# LSC Responses to TIS Redline Comments

## Windermere Zone Change Traffic Impact Study PCD File No.: P229 & SP223 (LSC #S224091) January 25, 2024

Figure 3

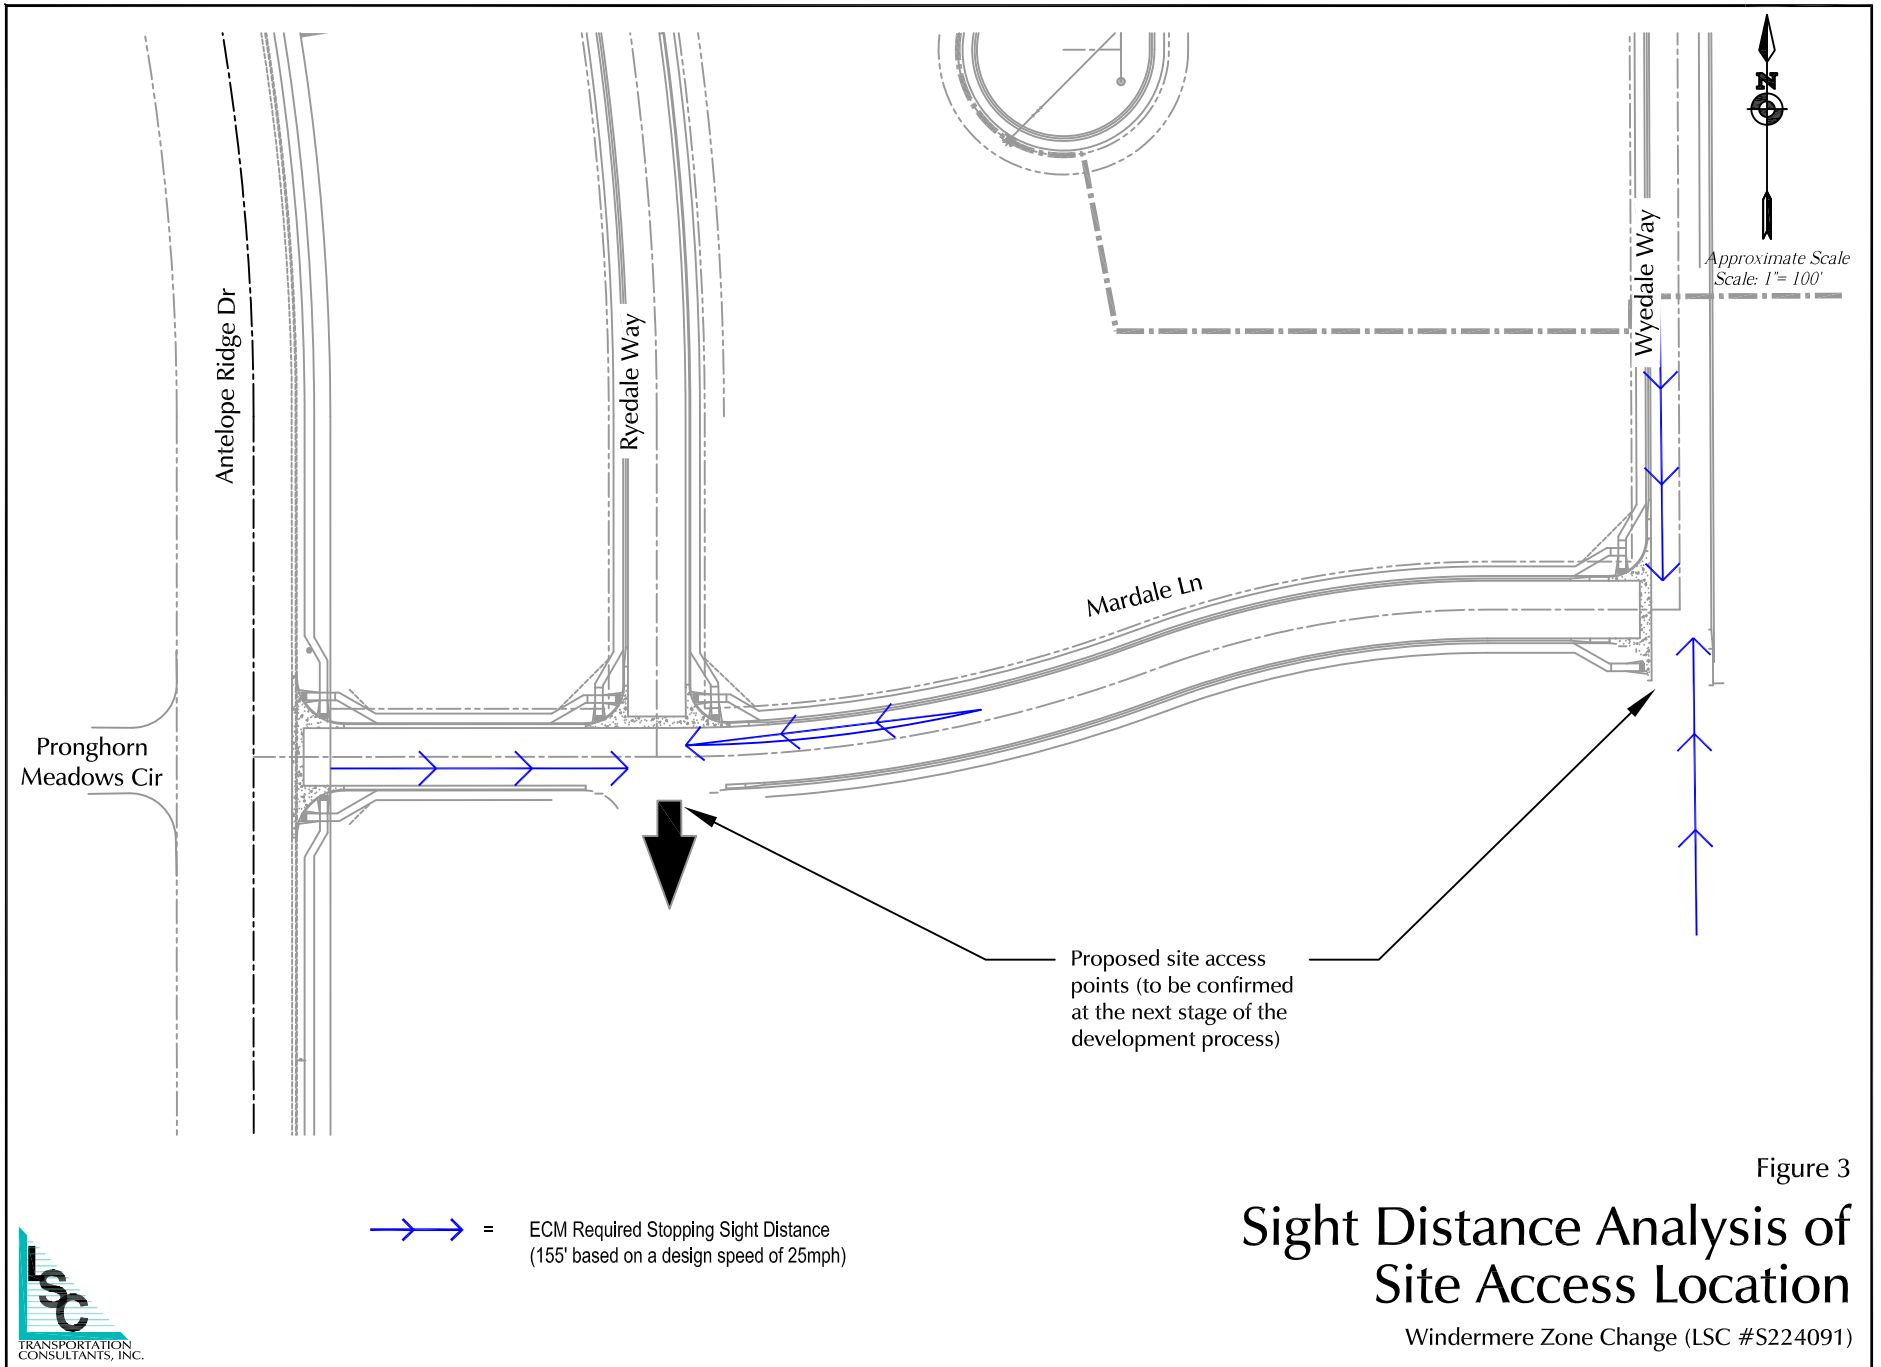
Number: 1  
Lake

Author: Kirstin Ferrin Subject: Sticky Note Date: 6/11/2024 9:56:20 AM  
LSC Response: The text has been revised.

Figure 4  
 Existing Traffic,  
 Lane Geometry, Traffic Control  
 and Levels of Service  
 Windermere Zone Change (LSC #S224091)

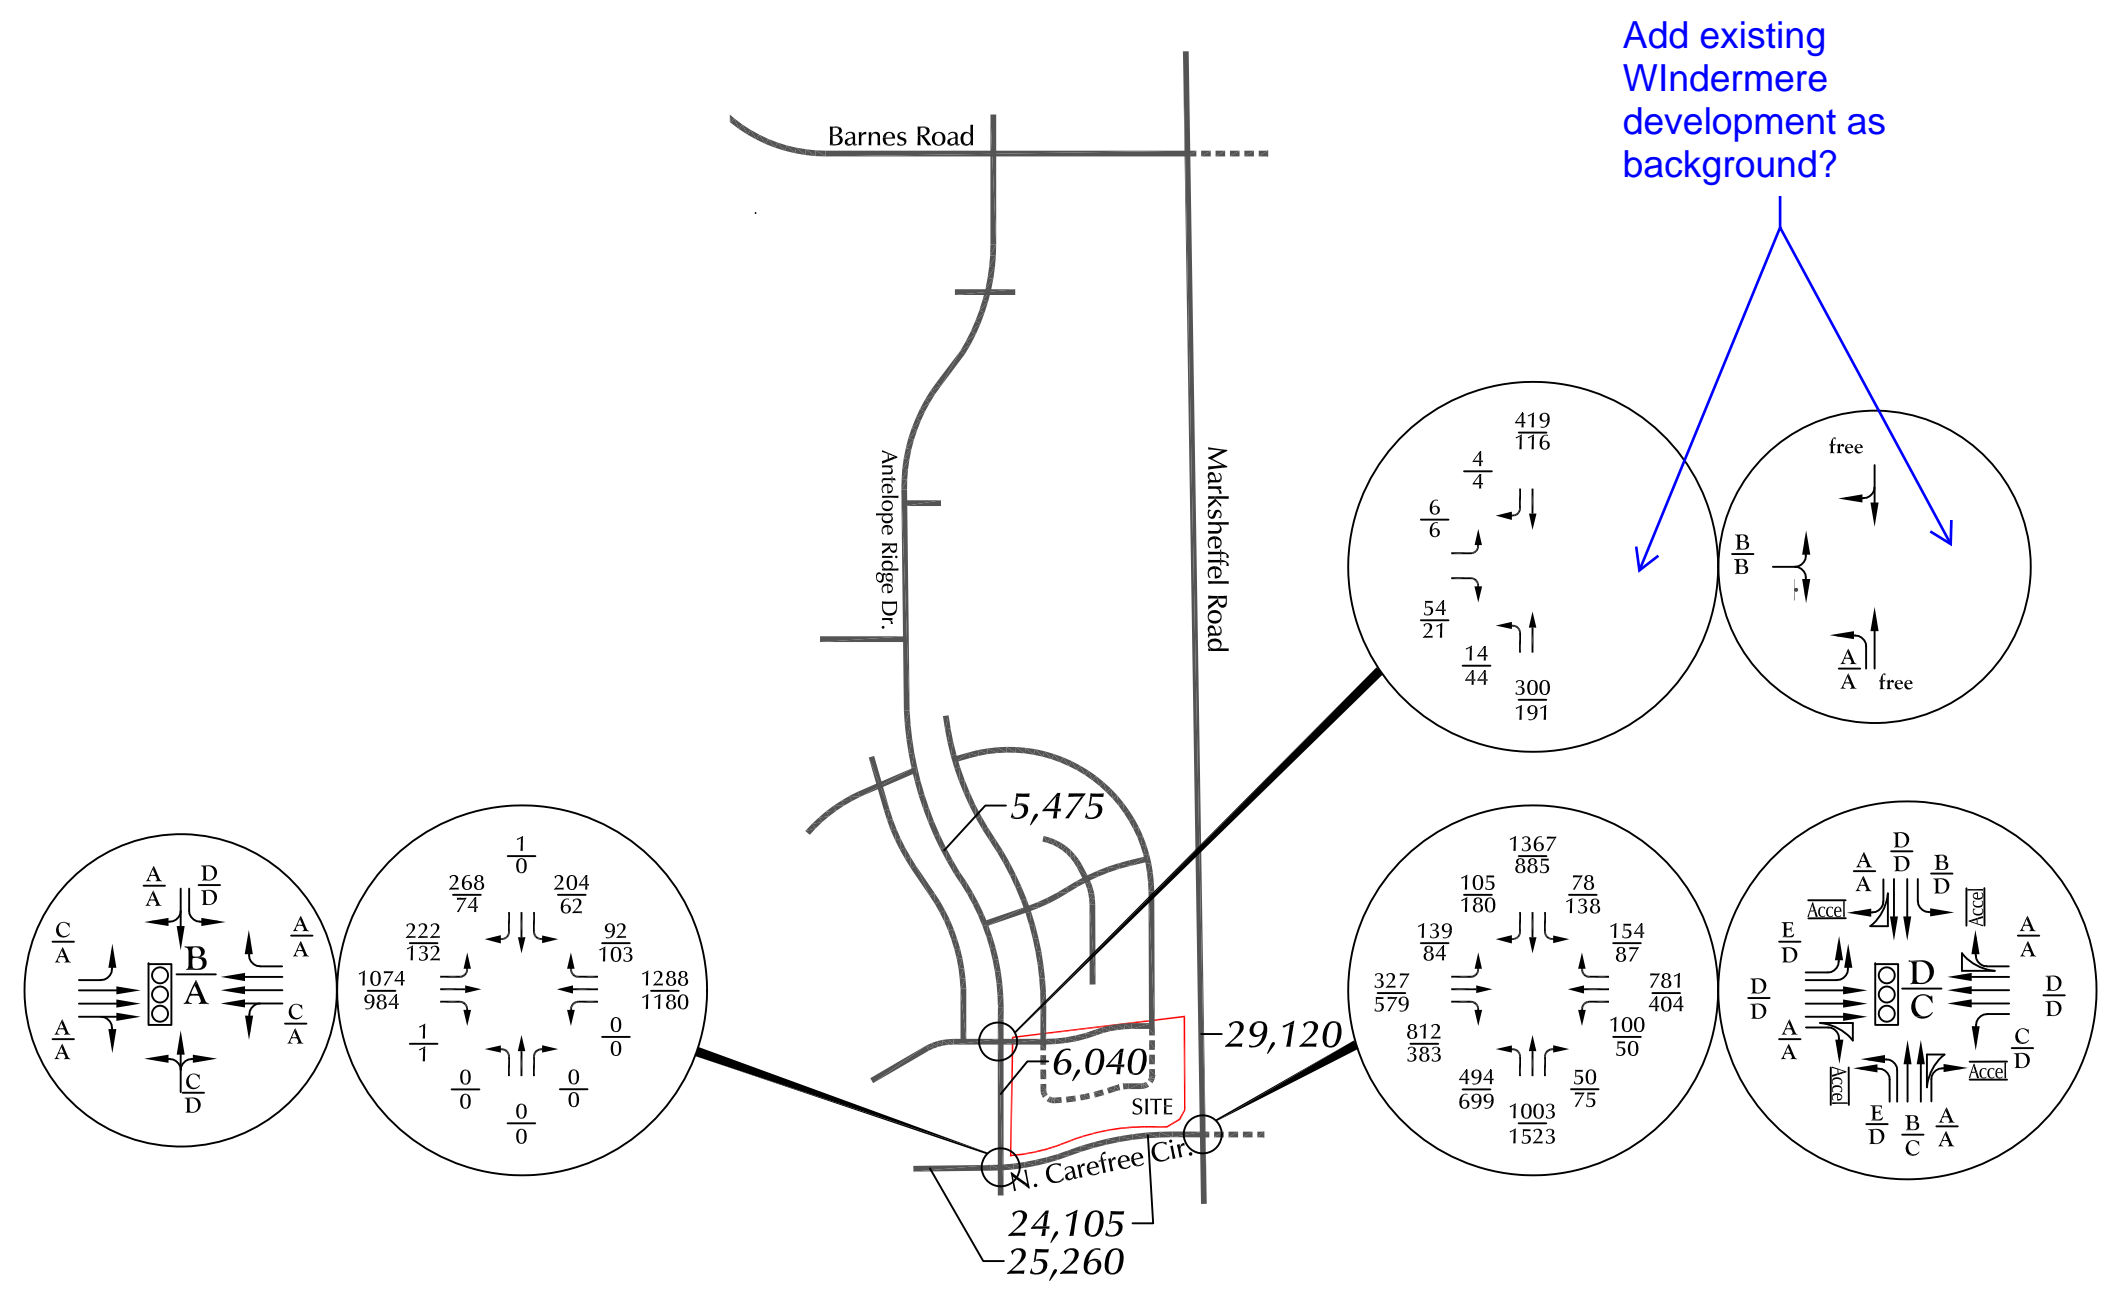
Number: 1 Author: Jeff Rice - EPC Engineering Review Subject: Callout Date: 4/24/2024 11:17:25 AM

Add note that development is currently ongoing on the east side

Author: Kirstin Ferrin Subject: Sticky Note Date: 6/11/2024 9:57:42 AM  
LSC Response: Revised as requested.

Figure 9
Short-Term Total Traffic, Lane Geometry, Traffic Control and Levels of Service

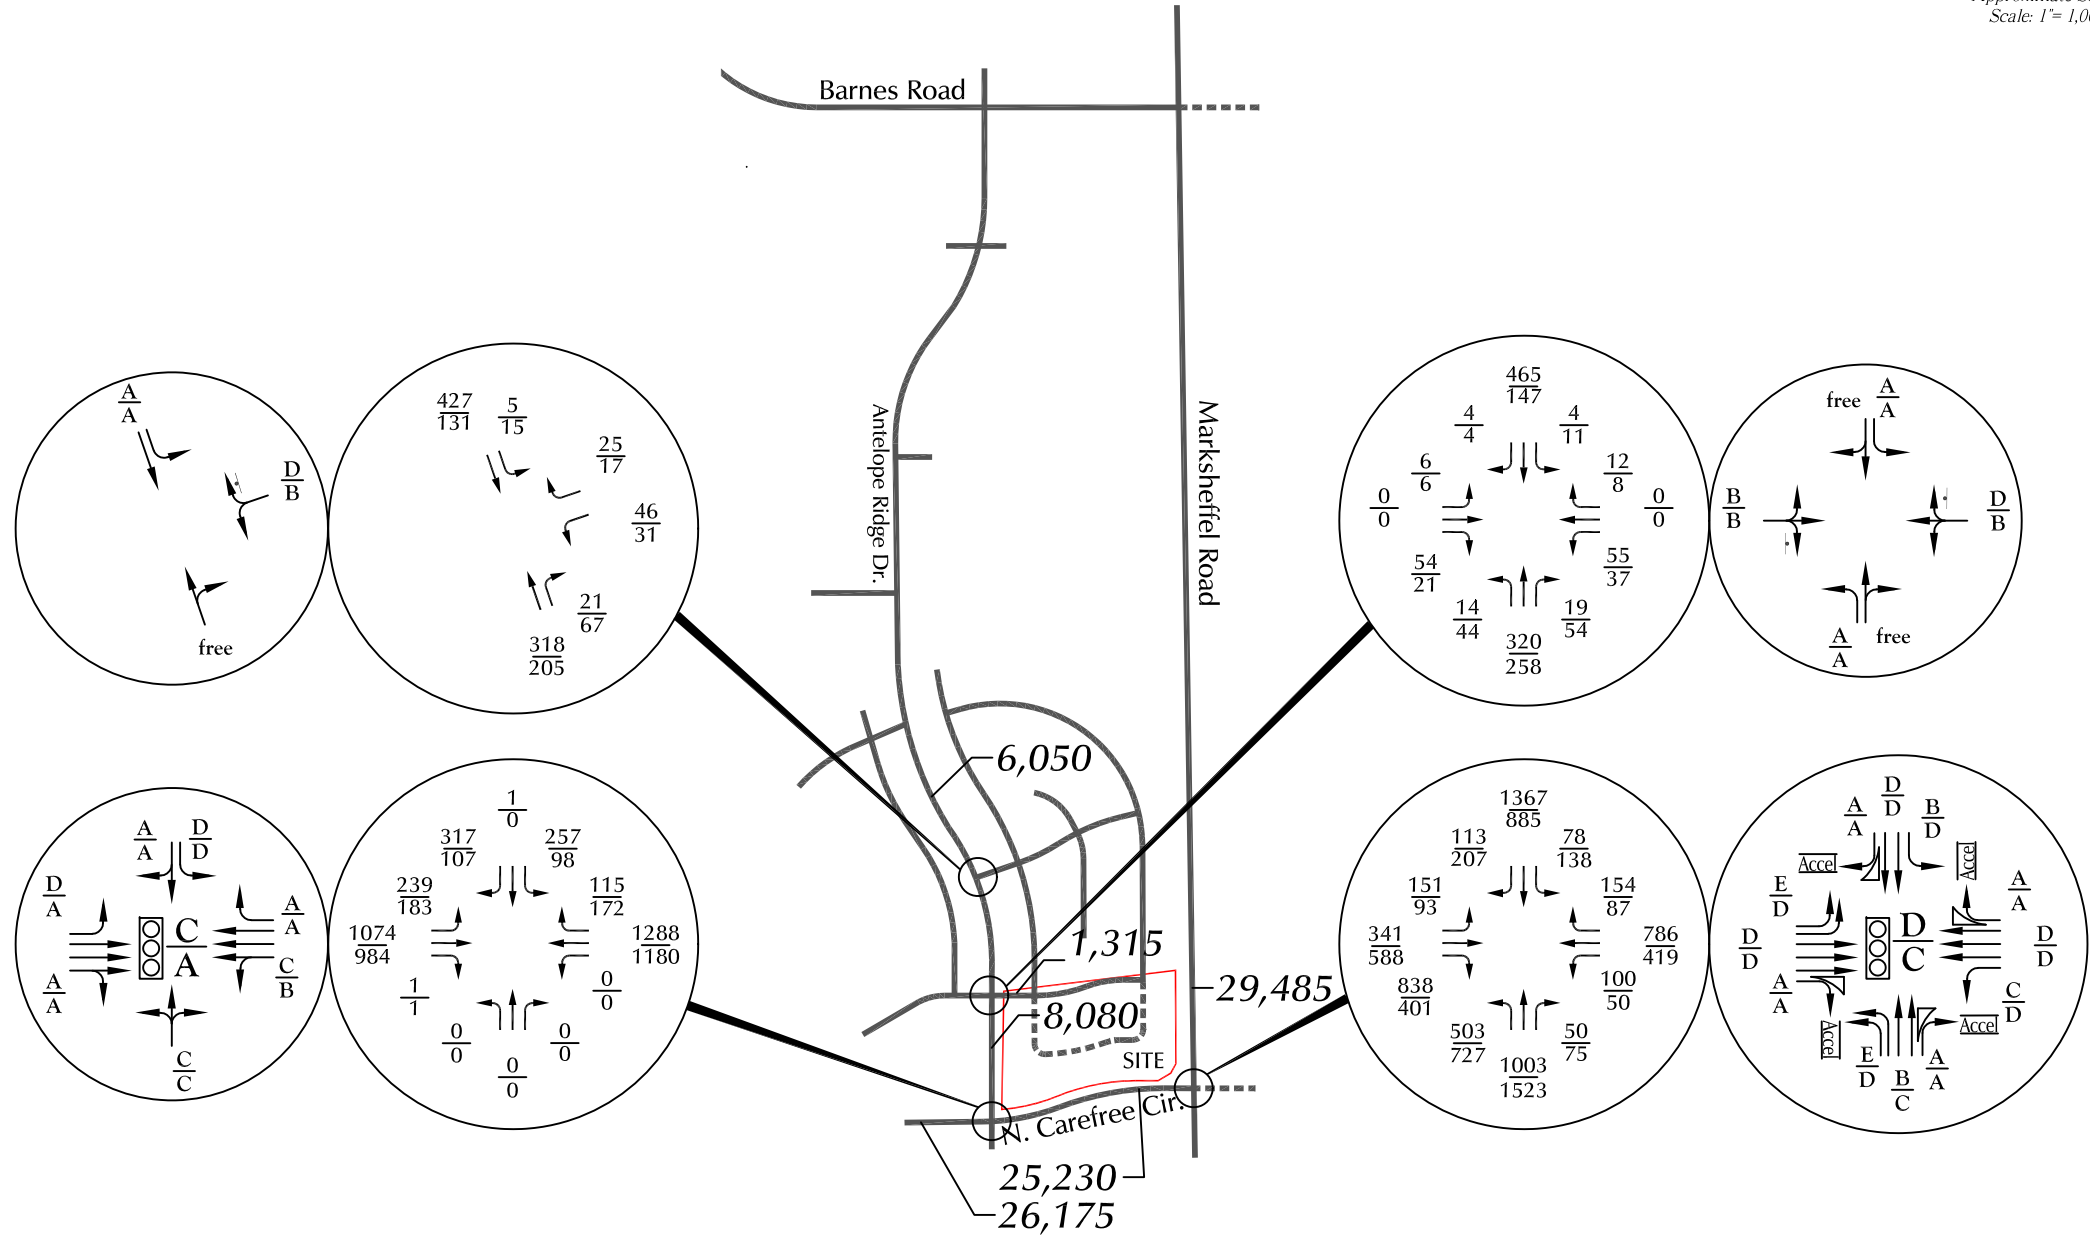
Please indicate year of short-term.

LSC Response: The additional information has been added as requested.
